**Modification 4 Design Development Application for Sydney Modern - SSD 6471**

Thank you for your referral dated 16 November 2020 inviting comments from the Heritage Council of NSW on the above State Significant Development modification proposal.

**Steven Meredith**  
Regional Manager,  
South  
Heritage NSW, Department of Premier and Cabinet  
**As Delegate of the Heritage Council of NSW**  
1 December 2020

Figure 6. Proposed Landscape Plan of the Vernon Curtilage under the Proposed Modification
Source: Gustafson Guthrie Nichol (GGN) Landscape Architects and McGregor Coxall Landscape Architects

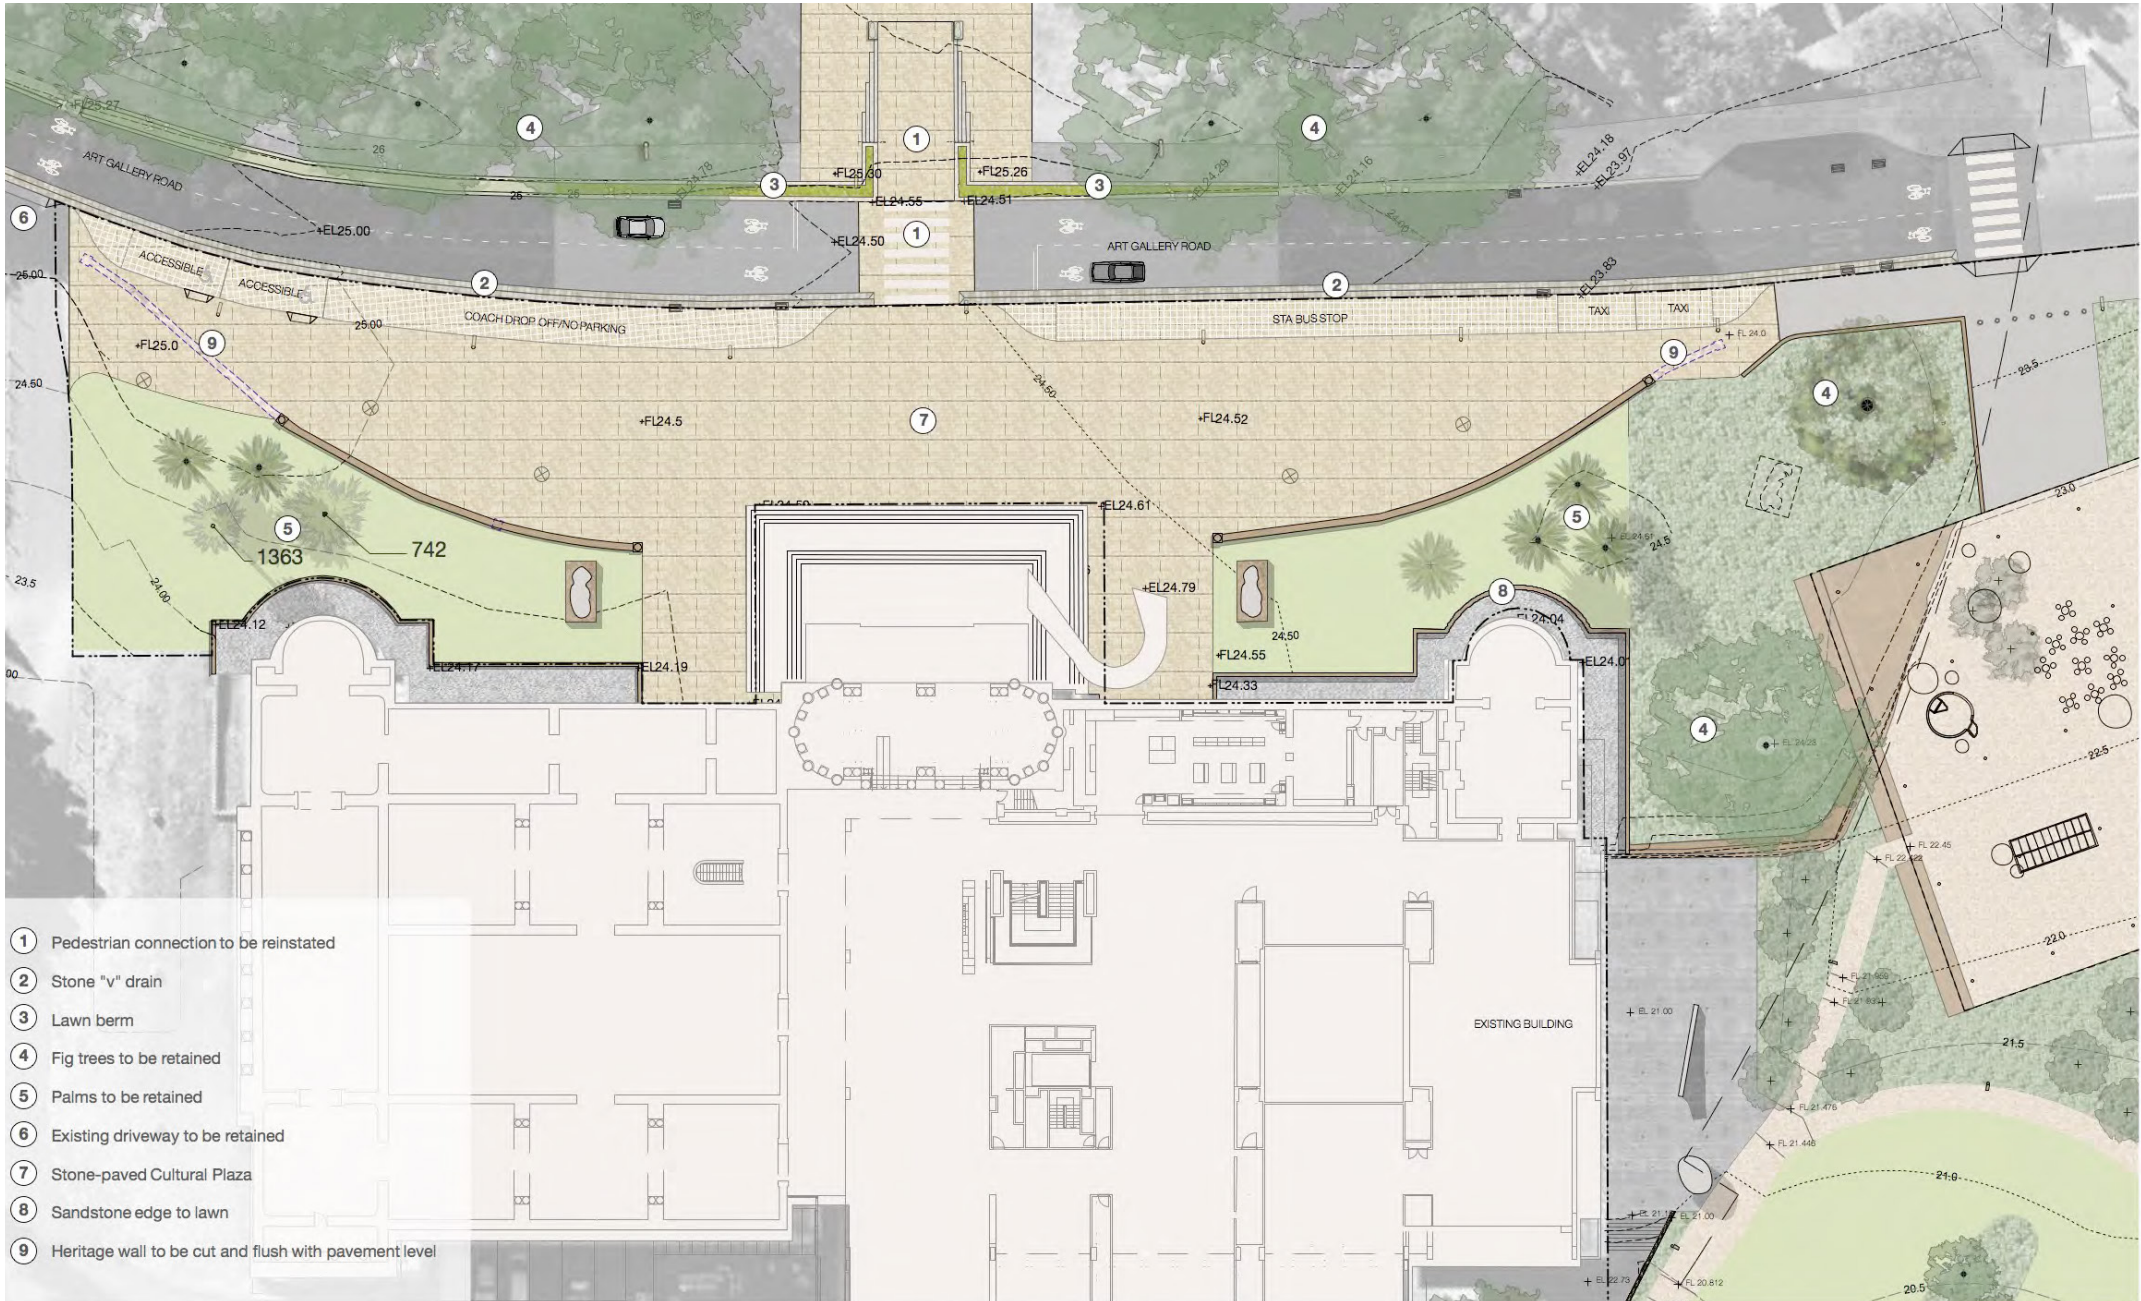
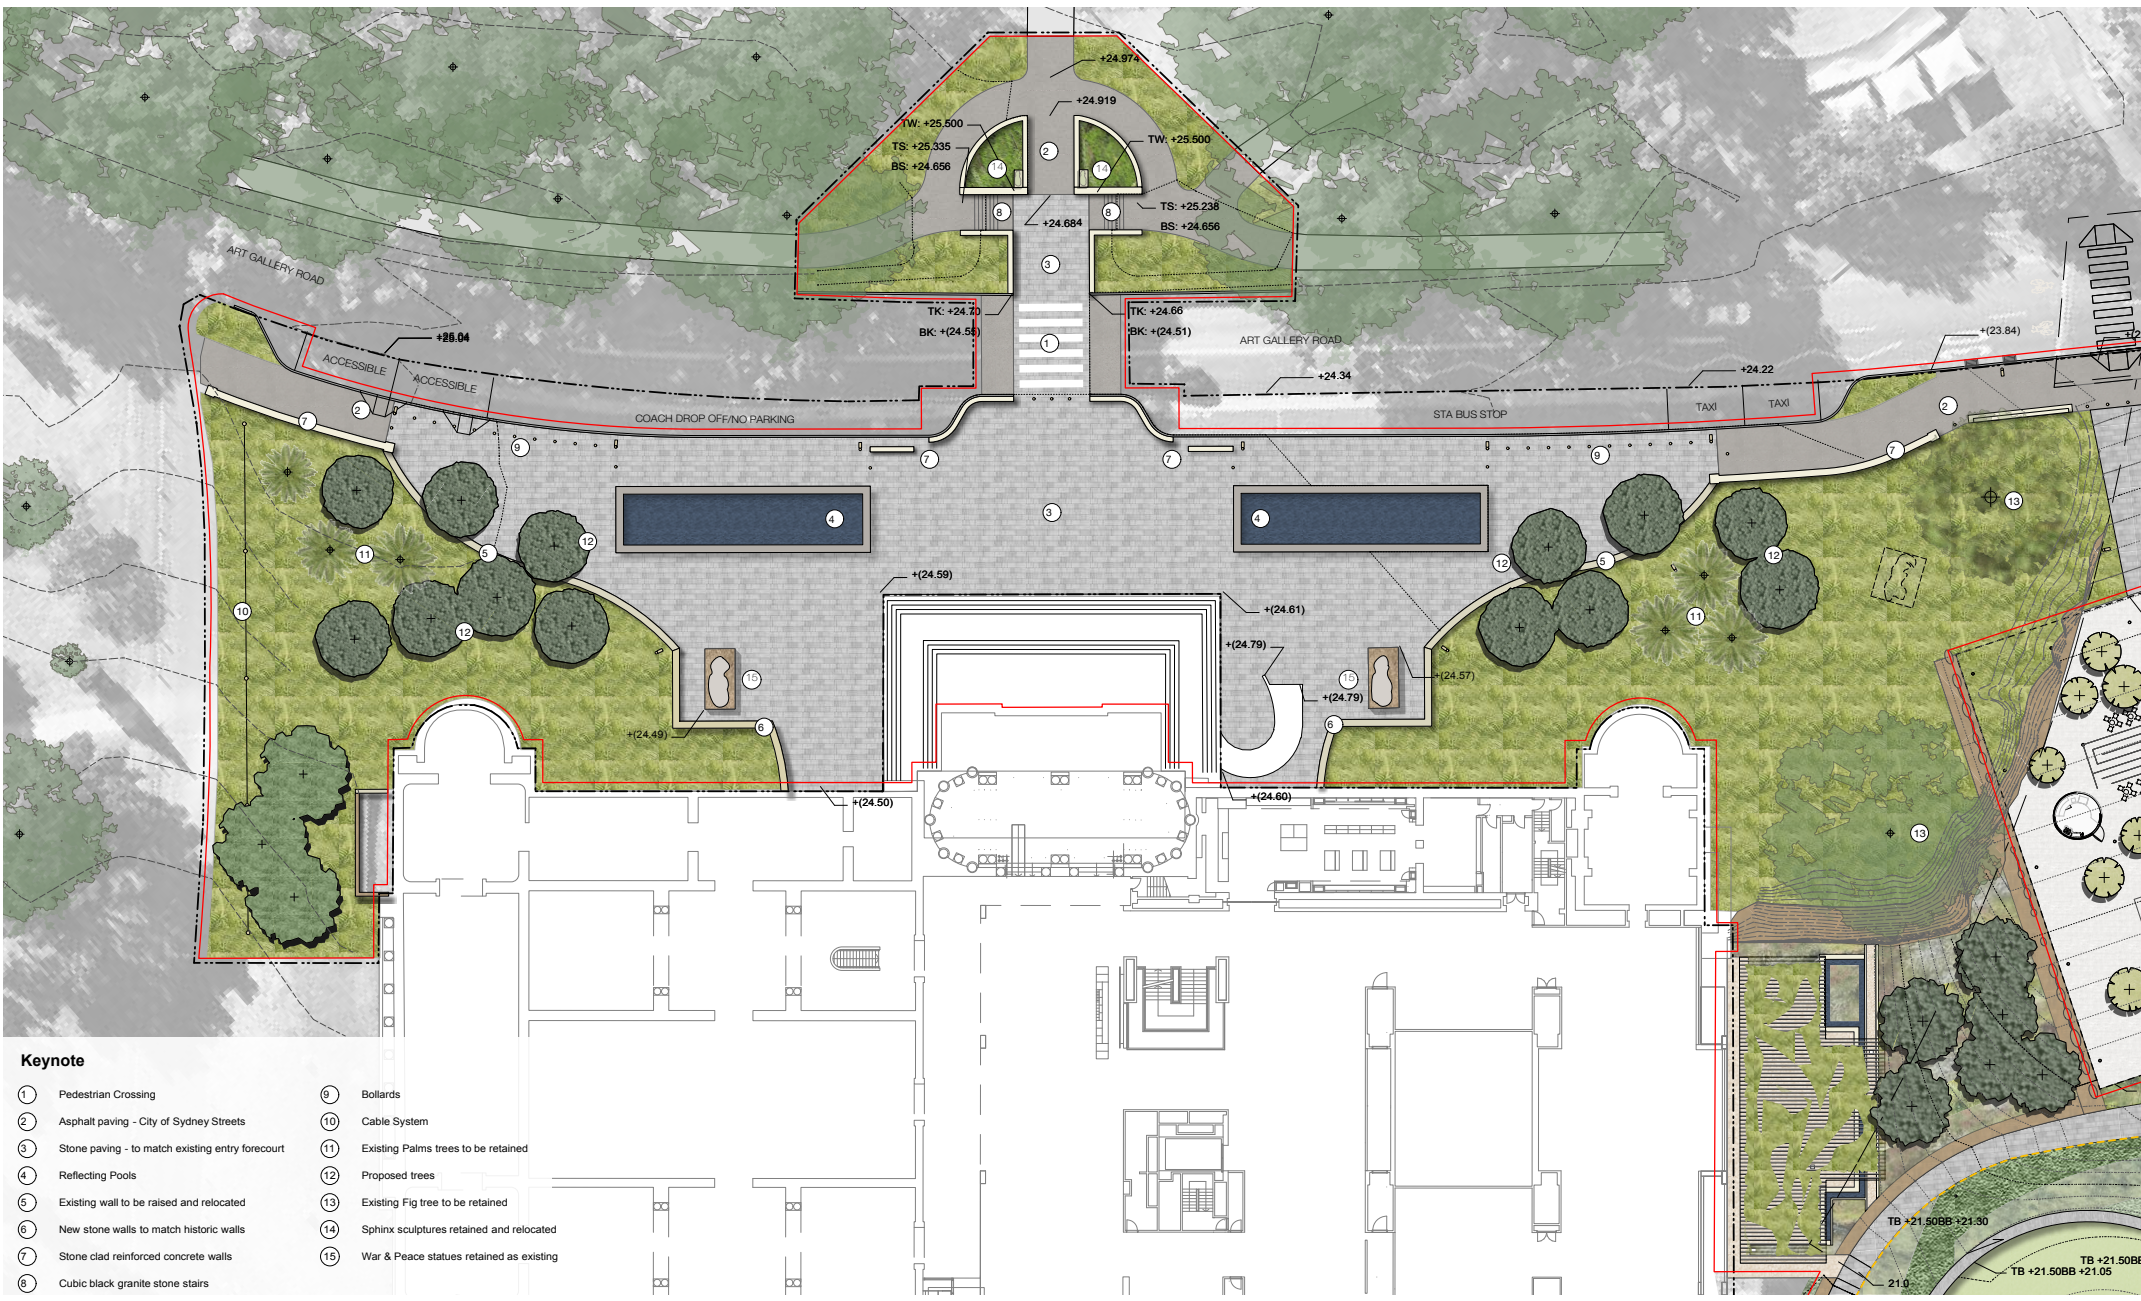
1. The addition of reflection pools above ground to either side of the existing Gallery building are located beyond the SHR curtilage. These above ground reflection pools are located within the Vernon curtilage which is of high significance and has remained largely unchanged since the early twentieth century. It is recommended that the pool height and footprint be reduced as much as possible to ensure that the impact upon historical views and the architect's original intent and design narrative be minimised as they may potentially appear as visual intrusions upon the Vernon Wing curtilage.

Figure 7. Landscape plan of the Entry Plaza, as approved under SSD 6471
Source: McGregor Coxall Landscape Architects

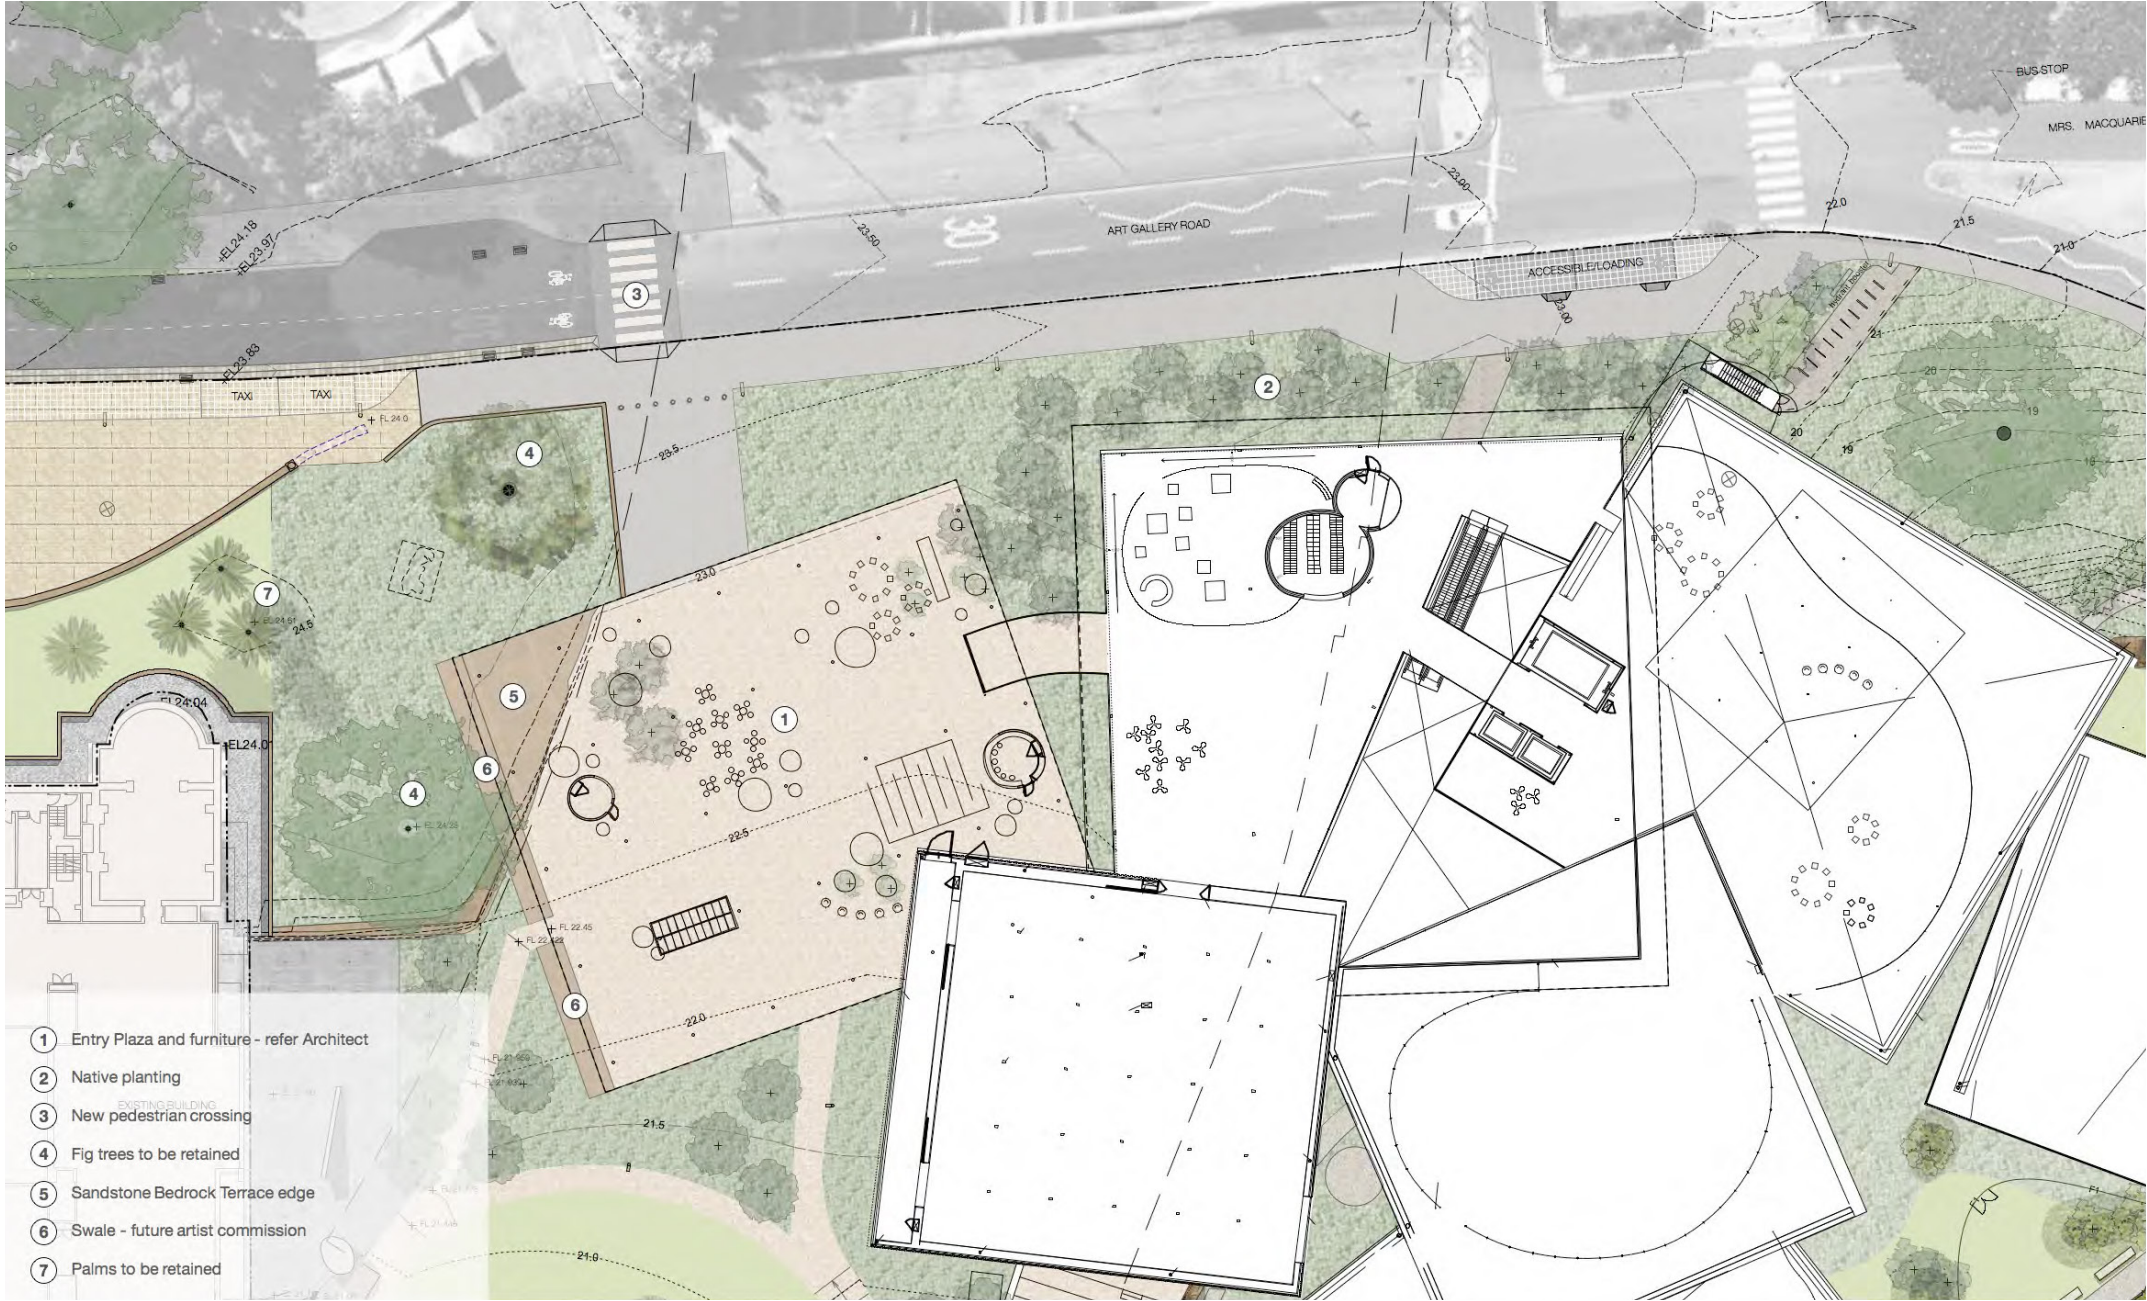
10. The Entry Plaza trees are proposed to be planted in pots rather than in the ground. At this time, the applicant has not provided detail on the age, height or canopy size of the trees. It is stated that these trees would be moved based on the use of the Entry Plaza and that it is unknown how the trees would fair being under-cover. This raises concern if these trees would remain as part of the Entry Plaza in the long-term and if they would satisfy the conditions of consent on tree plantation.
